East Pye Solar
Statement of Common Ground: South Norfolk
District Council

Revision 1
October 2026

Planning Inspectorate Reference: EN0110014
Document Reference: EN0110014/EXAM 9.5
Rule 8(1)(e) Infrastructure Planning (Examination Procedure) Rules 2010

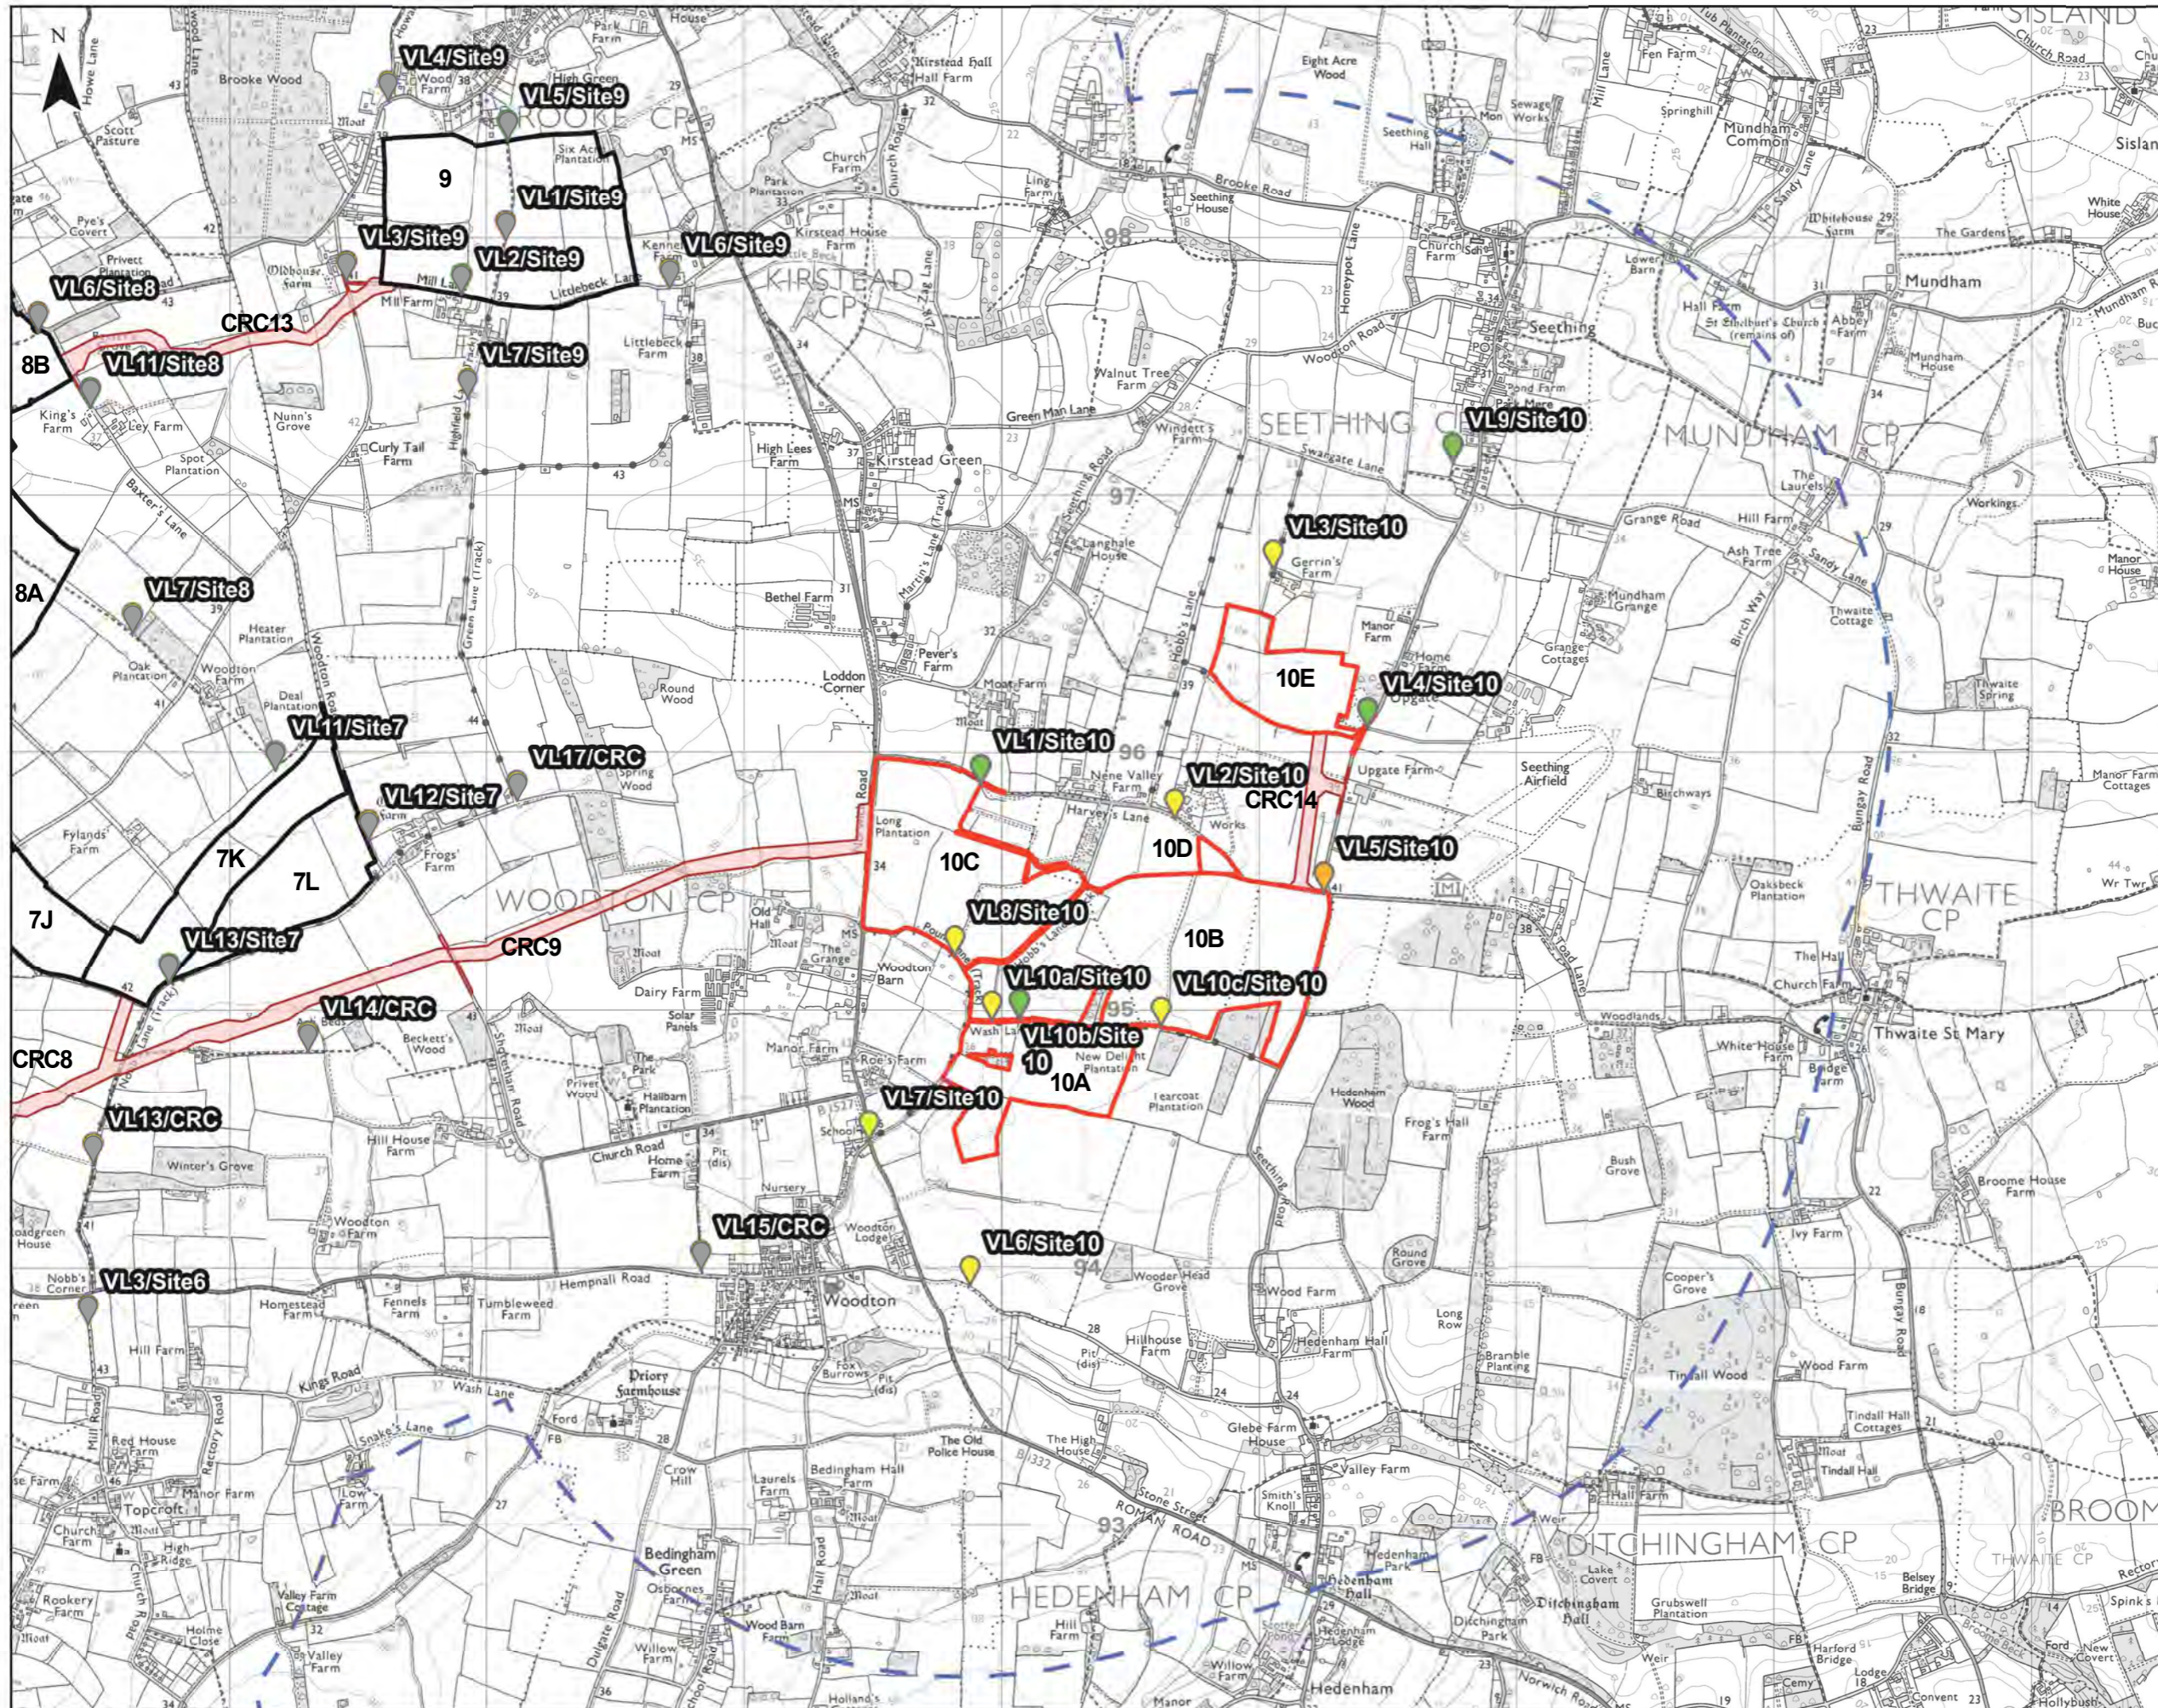
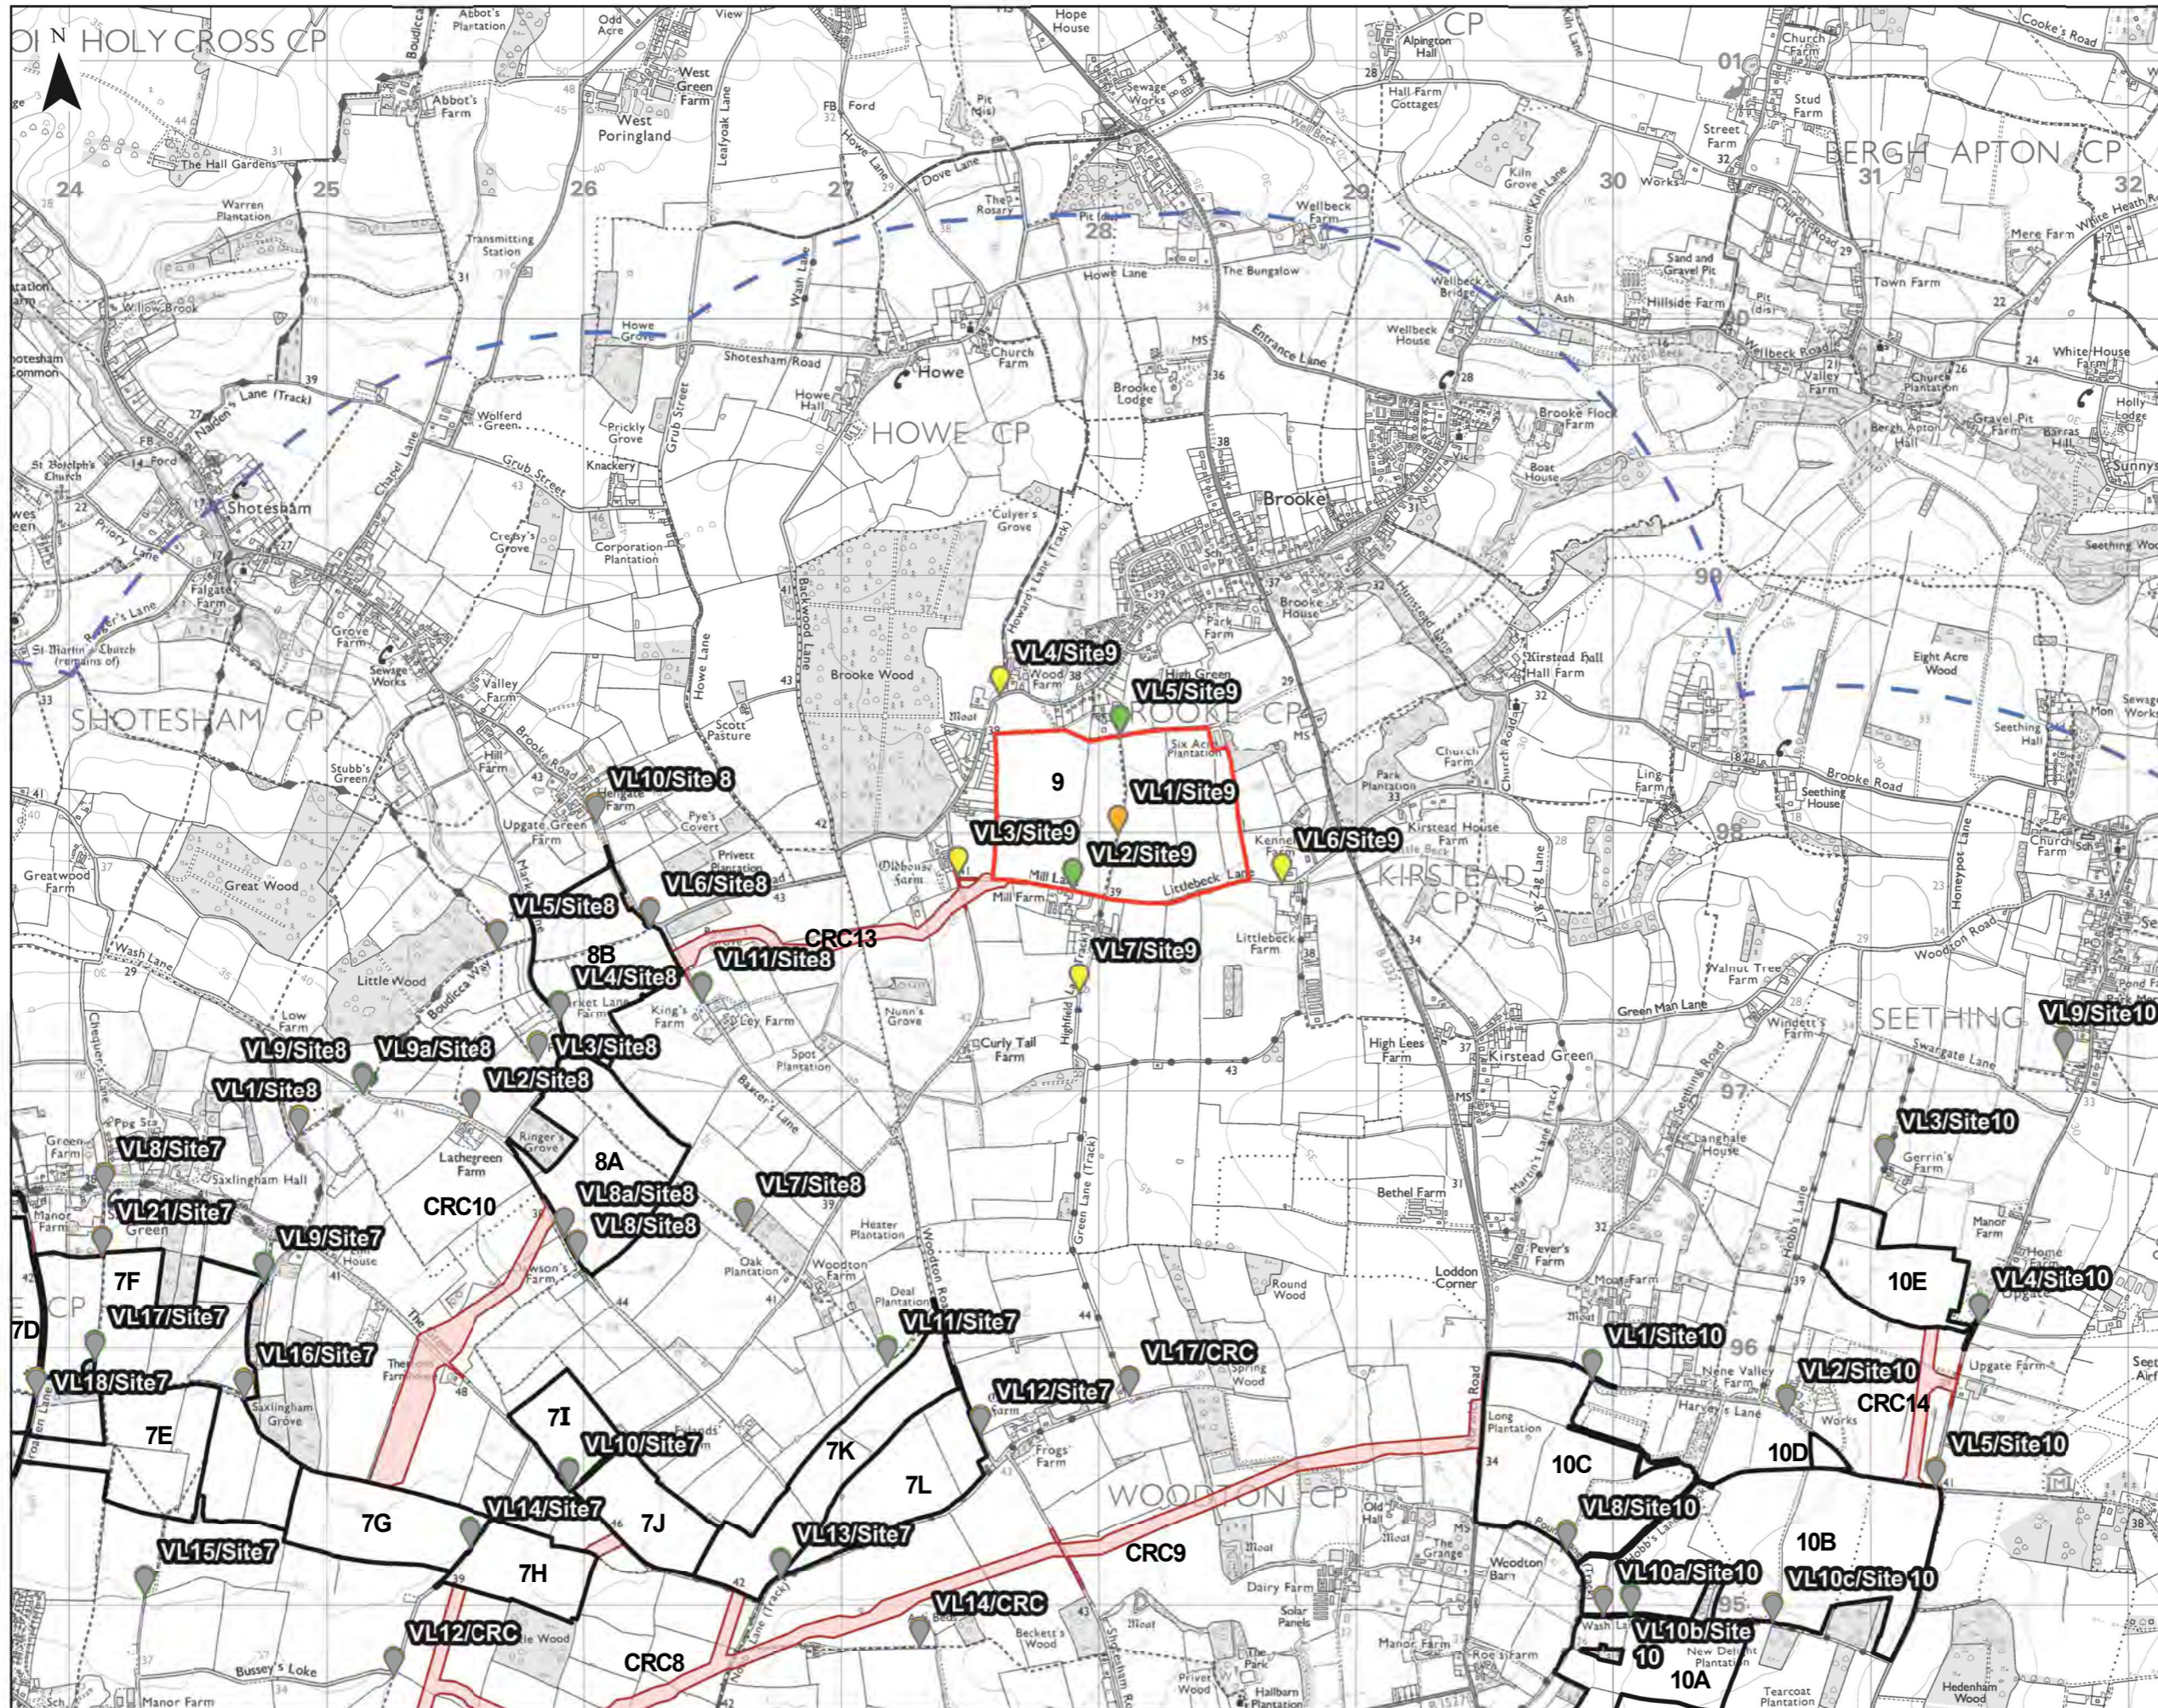
SNDC LV - 8	Scope View Location selection	ES Volume 1, Chapter 7 - Landscape and Visual [APP-043] ES Volume 2, Figure 7.7 - View Locations and Visualisations [APP-082]	The Applicant consulted with SNDC to agree view locations, and SNDC is content with the submitted materials.	The Applicant has undertaken consultation with the Landscape Officer in respect of the selection of assessment view locations. In response to comments received, a number of additional view locations have been incorporated into the assessment, including: VL8/Sub, VL8/LP2, VL7/LP3, VL8/LP3, VL9-VL12/LP4, VL7/LP5, VL9-VL11/LP8, VL7/LP9, VL10/LP10, VL16 and VL17/CR.	Agreed

SNDC LV – 10	Scope Visualisation for Landscape and Visual Assessment	ES Volume 1, Chapter 7 - Landscape and Visual [APP-043] ES Volume 3, Appendix 7.1 - Landscape and Visual Methodology [APP-118] ES Volume 2, Figure 7.7 - View Locations and Visualisations [APP-082]	SNDC agree that the submitted visual technical visualisations cover a reasonable number of viewpoints and locations however they should have been prepared as Type 4, not Type 3, to guarantee an appropriate level of accuracy for such complex and sensitive development.	The Applicant has consulted with the Landscape Officer in respect of the location and type of visualisations to be produced, but no response was received. The location and type of visualisations are illustrated in ES Volume 2, Figure 7.7 - View Locations and Visualisations [AS-009]. The methodology for visualisation production is set out in ES Volume 3, Appendix 7.1 - Landscape and Visual Methodology [APP-118]. The visualisations have been prepared in accordance with industry-standard guidance, specifically the Landscape Institute [2019] Visual Representation of Development Proposals Technical Guidance Note 06/19 [TGN 06/19]. The types of visualisation produced include: • Photowires [LI TGN 06/19 Type 3]; • Photomontages / Photowires for Winter Year 1 [LI TGN 06/19 Type 3] with no landscape measures shown; and • Photomontages Summer Year 15 [LI TGN 06/19 Type 3] with established landscape measures shown. The parties will continue discussions regarding the requirement and potential locations of Type 4 visualisations.	Under discussion

Reference	Matter Topic	Document Reference of Matters	Consultee Position	Applicant's Position	Status
				The view locations presented within ES Volume 1, Chapter 7 - Landscape and Visual [APP-043] and ES Volume 2, Figure 7.7 - View Locations and Visualisations [APP-082] are therefore considered to provide an appropriate and robust basis for establishing baseline landscape and visual conditions.	
SNDC LV-9	Scope View Location Selection	ES Volume 1, Chapter 7 - Landscape and Visual [APP-043] ES Volume 2, Figure 7.7 - View Locations and Visualisations [APP-082]	Following a review of the submitted documents with the DCO, SNDC consider that additional viewpoints from the Via Beata, Boudicca Way, and from footpaths within the sites or on the site's boundaries would be beneficial to illustrate worst-case scenarios and the extent of change for sensitive visual receptors and the suggested locations are listed in SNDC's Local Impact Report.	This matter will remain under discussion until SNDC's Local Impact Report is received.	Under Discussion
